TO: Ms. Kelly Bacon, ET I
COPY: Lucas Huck, County Road Engineer
DATE: May 15, 2017
FROM: Mark R. Cook, Director 
RE: Currier Heights

Lacking any additional detail, the supplied plat drawing of Currier Heights is insufficient for Public Works to provide specific comments to Community Development. General comments concerning transportation and stormwater management are provided below for Community Development Services consideration.

SHEET CONTENTS
SITE PLAN

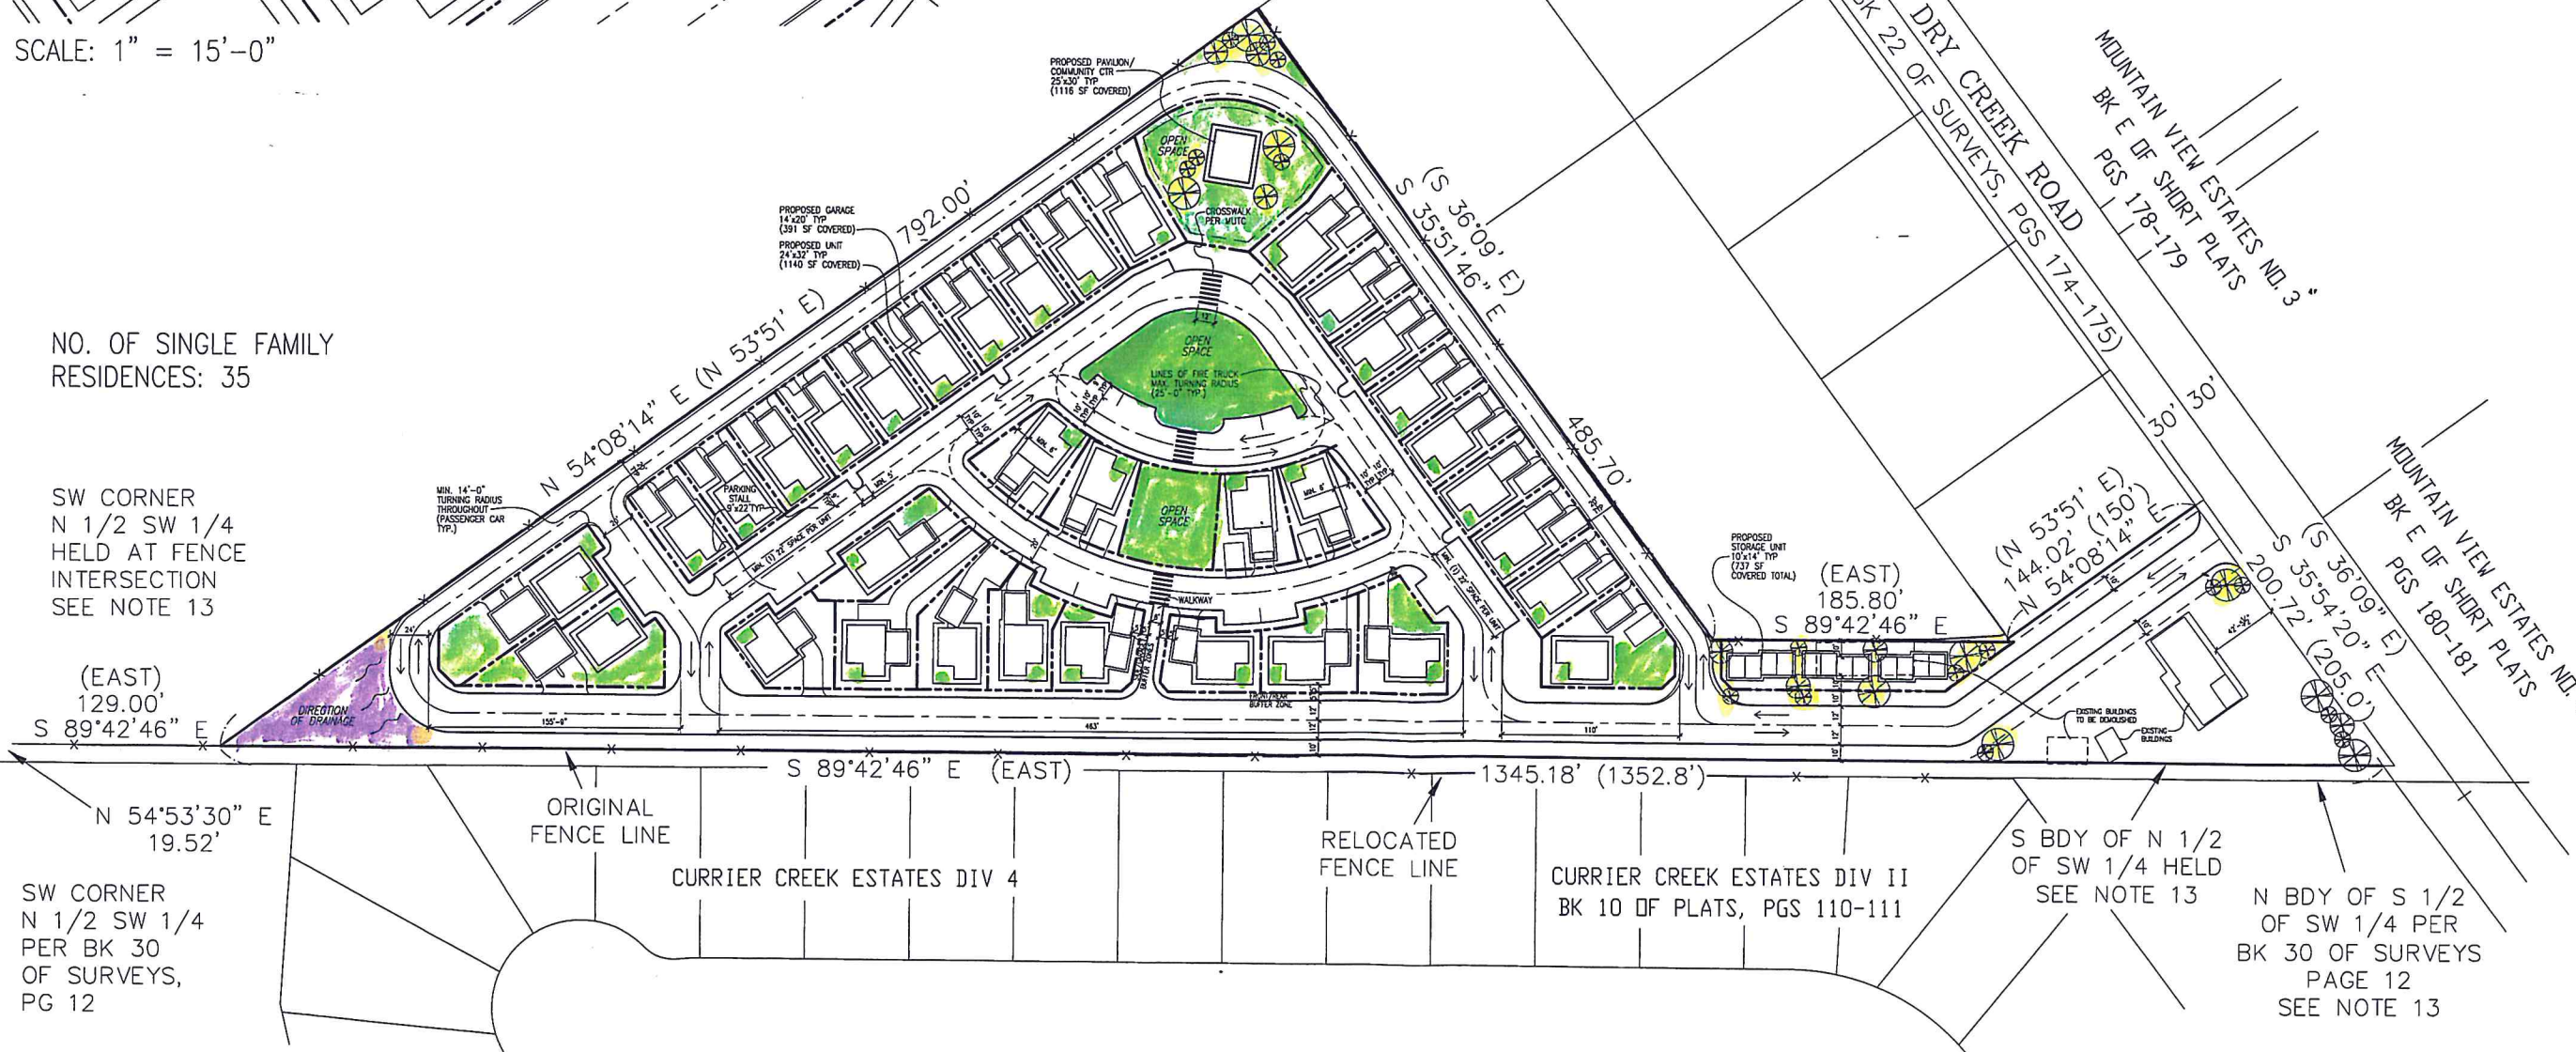
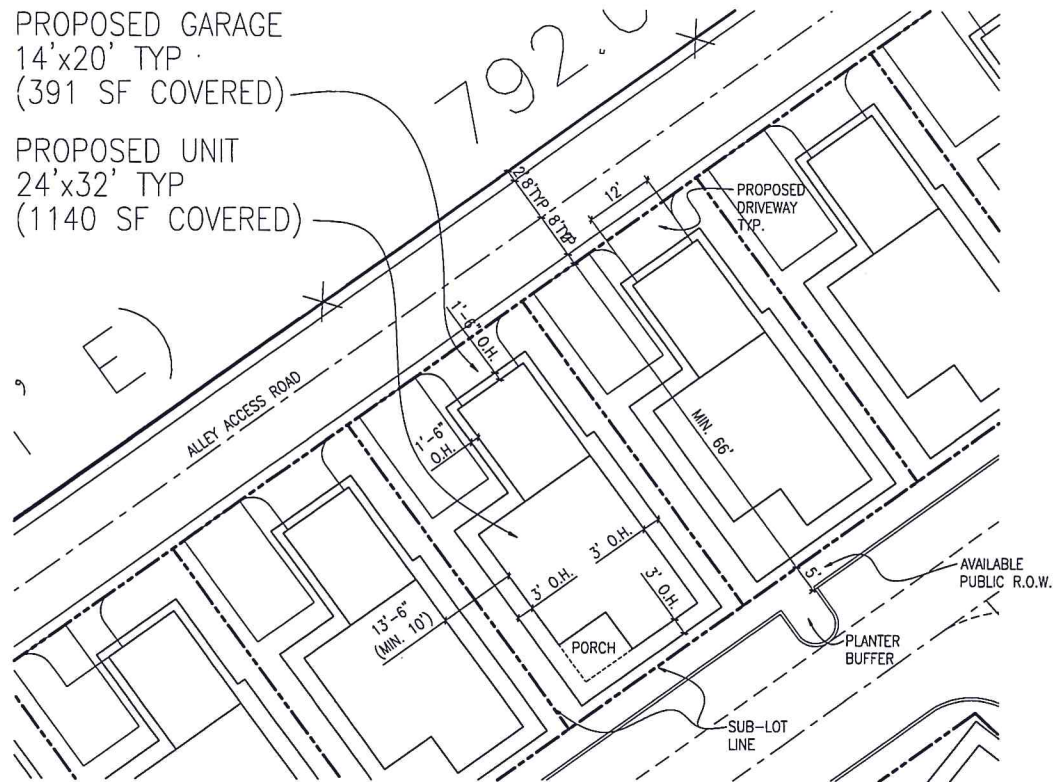
1. Kittitas County Code 12.04.040(b) (Design Criteria within an Urban Growth Area) affords final approval of the road alignment, geometry and construction requirements to the City of Ellensburg (Currier Heights). This same section references the "more stringent" of the County or City standards apply. Taken together, I interpret our code to mean the County's right of way requirements together with the wider of the two jurisdiction cross-sections with curb-gutter-sidewalk on all roadways. Given this requirement, the proposal provides far too little detail to comment further on the road proposal serving the plat. The submitted materials are insufficient for further staff review.

2. The plat is located in a known area of flooding. Two recently purchased homes in Currier Creek Estates proximate to this proposal have experienced flooding this past spring. The proposal is insufficient in detail allowing me to understand how runoff from the site will be mitigated. It is likely that no offsite discharge will be allowed from the site given known flooding in the area. The submitted materials are insufficient for further staff review.

3. I have been provided data suggesting that the site contains freshwater emergent wetlands. The provided plat map makes no notice of associated wetlands. The presence of potential wetlands further complicates the stormwater treatment and disposal scheme supporting plat development. The submitted materials are insufficient for further staff review.
